Subdivision PH Comments

Date: 02/12/2018

RE: Mitchell [SP-17-00003 \(correction to comments submitted 2/9/18 re: clarification to 1/18/2018 comments\)](#)

NANEUM ROAD SHORT PLAT  
 PART OF SECTION 33, T. 18 N., R. 19 E., W.M.  
 KITTITAS COUNTY, WASHINGTON

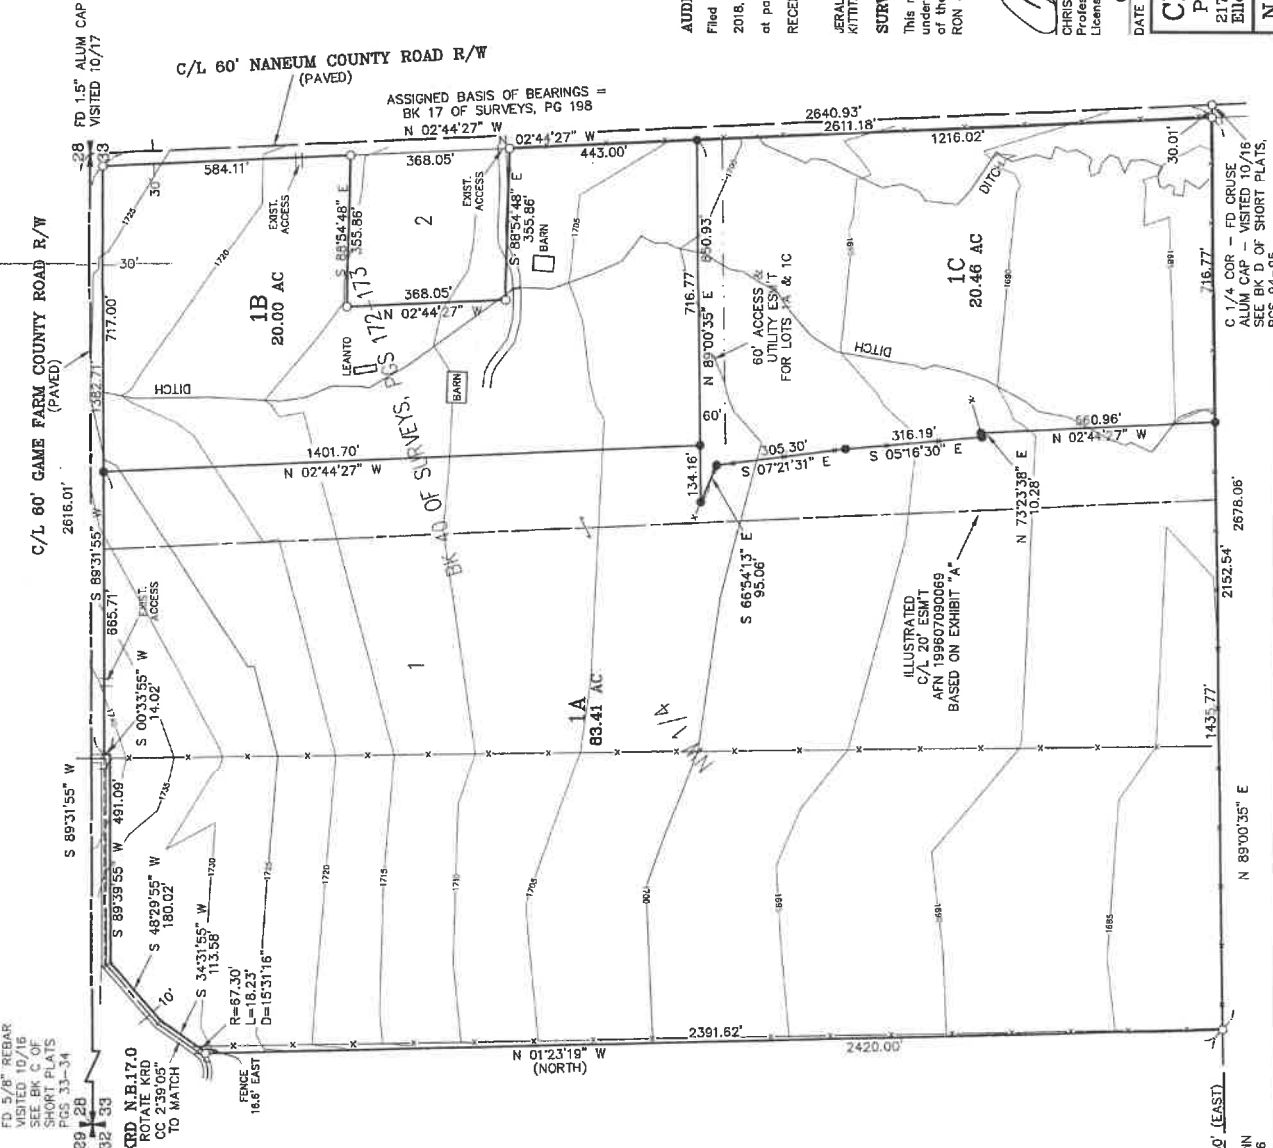
Thank you for the opportunity to comment on the above mentioned project regarding water and septic requirements to comply with Kittitas County Public Health requirements. The following items must be addressed *prior to preliminary plat approval*: Proof of water adequacy includes a well log or 4 hour draw down test, a mitigation certificate for each proposed lot and soil logs for Onsite Septic Systems must be completed at the frequency of one soil log per lot. (KCC 13.04.090 (1f)).

16. Well location. The drawings shall be marked with a "w" indicating location of the well and a broken line showing the one hundred foot radius around such.

All wells must meet the distance requirement of 50 feet from the property line, 50 feet from the septic tank and 100 feet from the drain field as per Kittitas County Critical Areas Ordinance 17A.08.25, and KCC Chapter 13. If existing wells do not meet the setback requirement from property lines, the two adjoining parcels nearest the well must enter into a legal, shared well-users agreement.

16.12.030 Existing conditions – Unless otherwise indicated, the following shall be shown on the preliminary and final drawings. (7) One soil log shall be performed and information recorded for each lot within the proposed subdivision. Soil logs shall be in accordance with WAC 246.272A.
